<b>Your ref</b>	3/2011/1071
<b>Our ref</b>	DC/12/802
<b>Date</b>	05-MAR-12

**Location: Land at Chapel Hill, Longridge, Lancashire**  
**Proposal: Erection of 52 Dwelling and conversion of barn to dwelling**

Daniel McDermott  
Developer Services & Asset Protection  
United Utilities

Drawing title:
Site Layout Plan as Proposed
Affordable Units

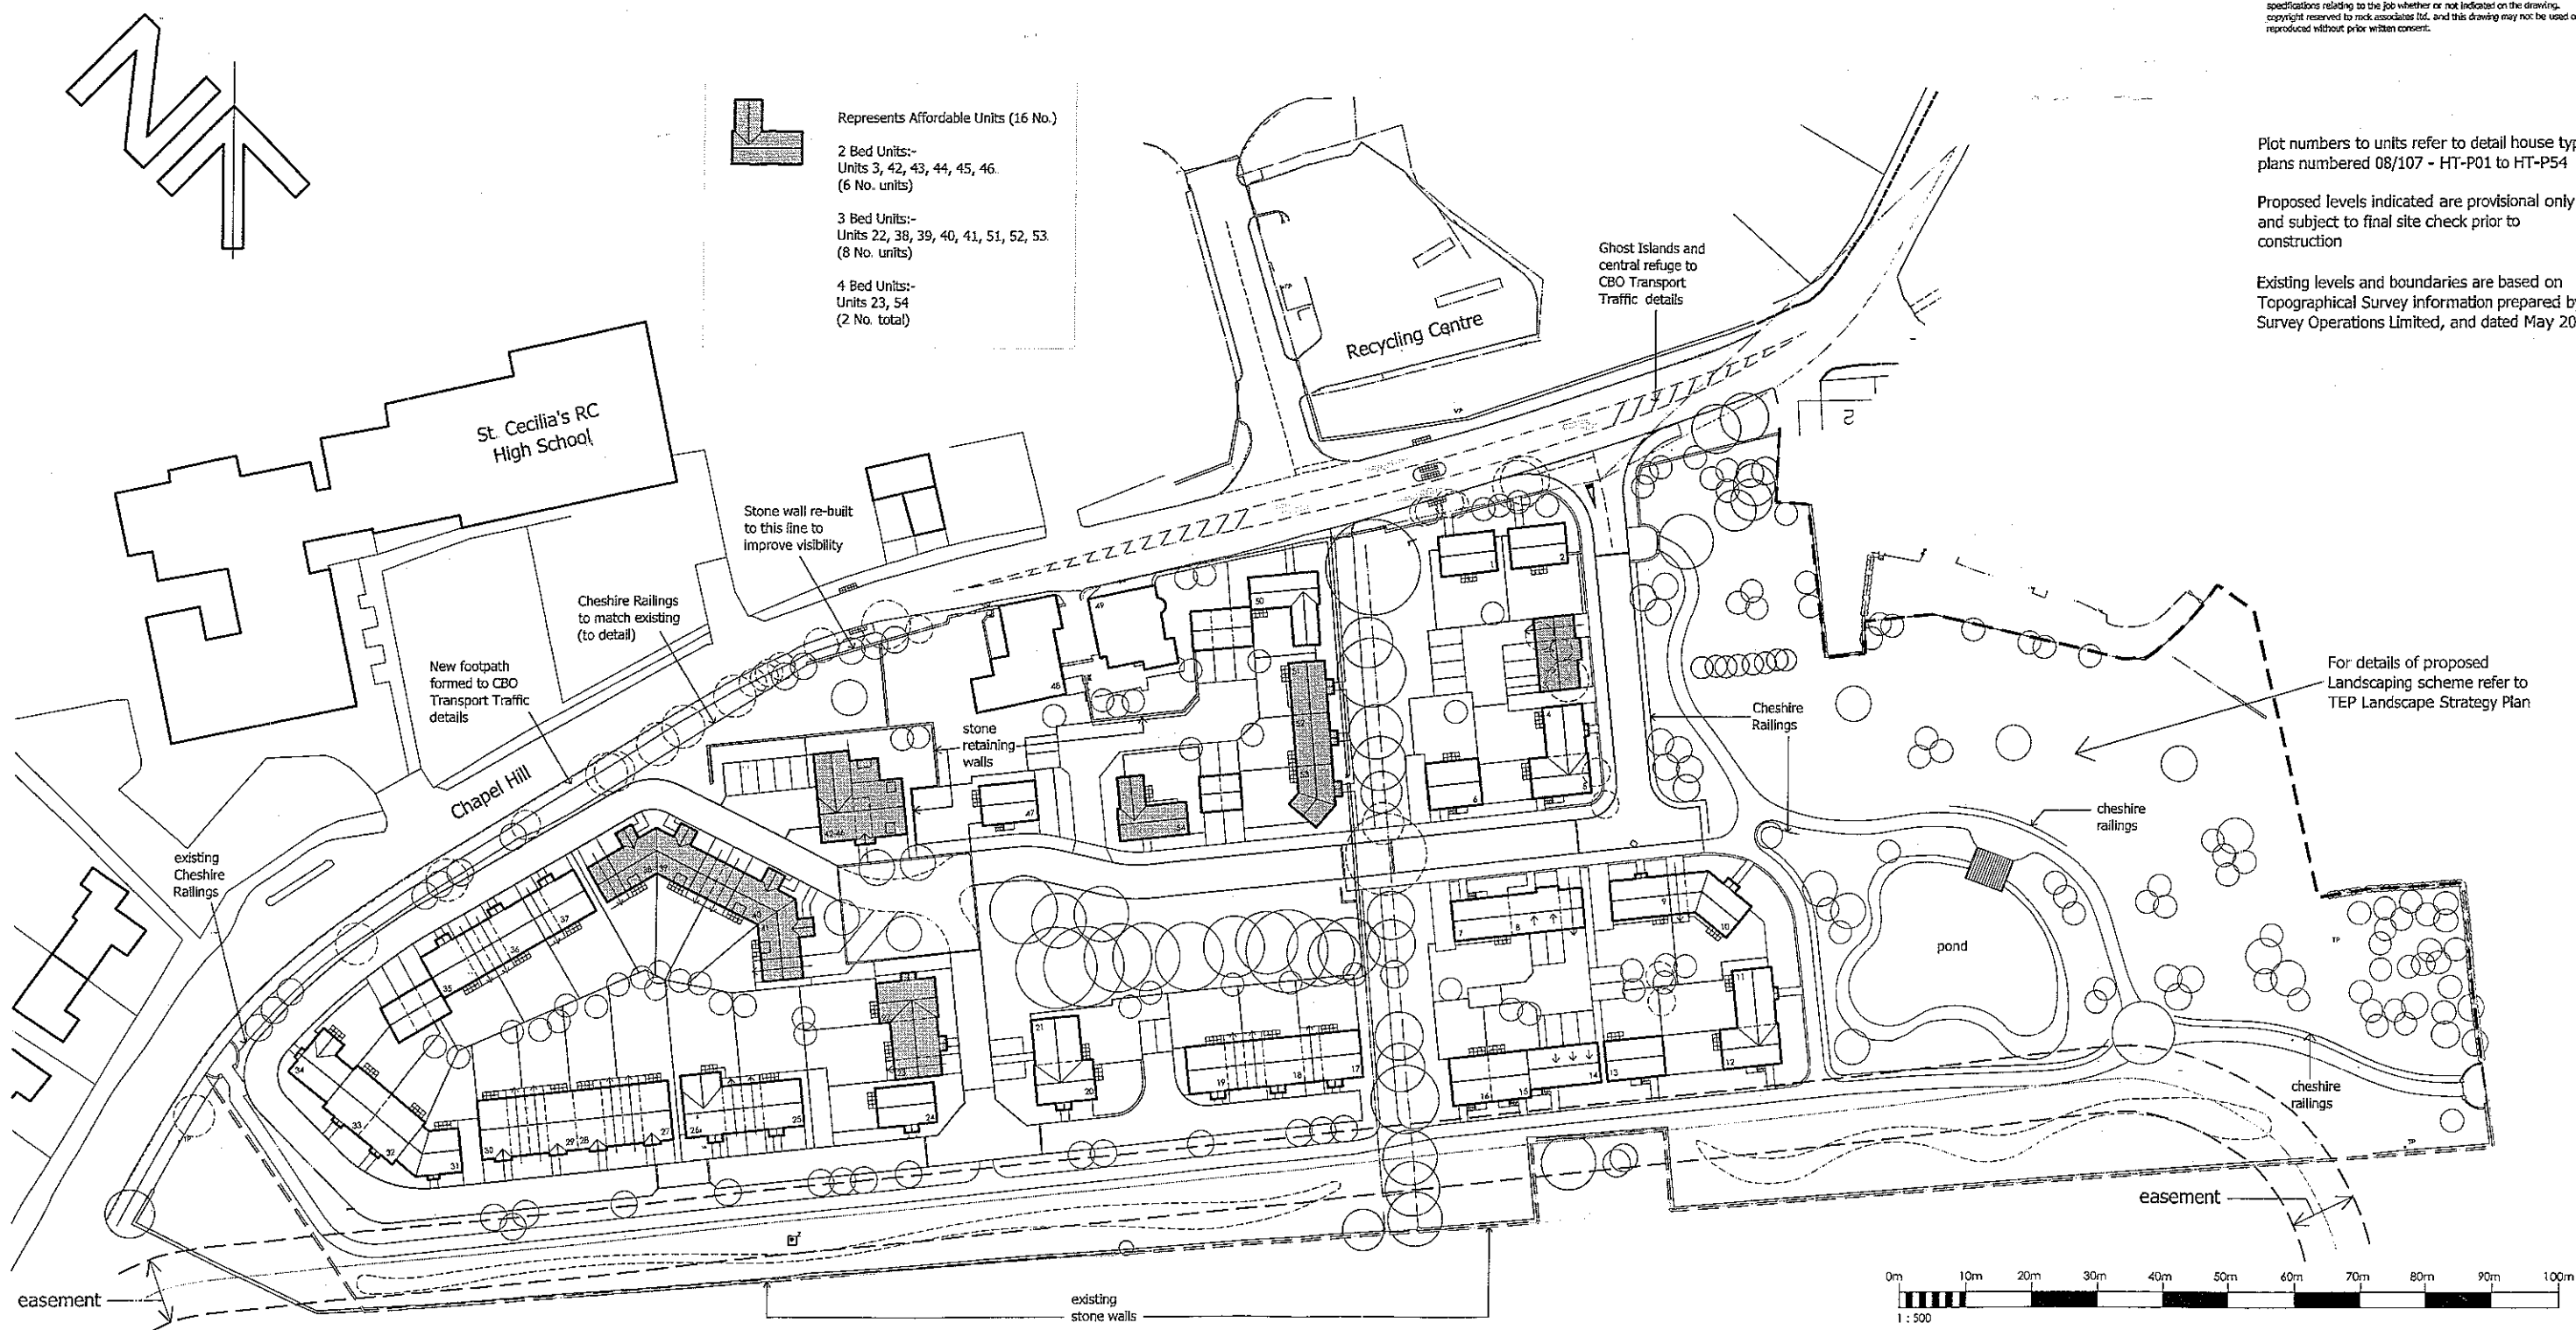
- A large diameter water main runs along the southern boundary of the site. As we need access for operating and maintaining it, we will not permit development in close proximity to the main.

A modification of the site layout, or diversion of the main at the applicant's expense, may be necessary.

This should be taken into account in the final site layout, or a diversion will be necessary, which will be at the applicant's expense.

You will need an access strip of 10m.
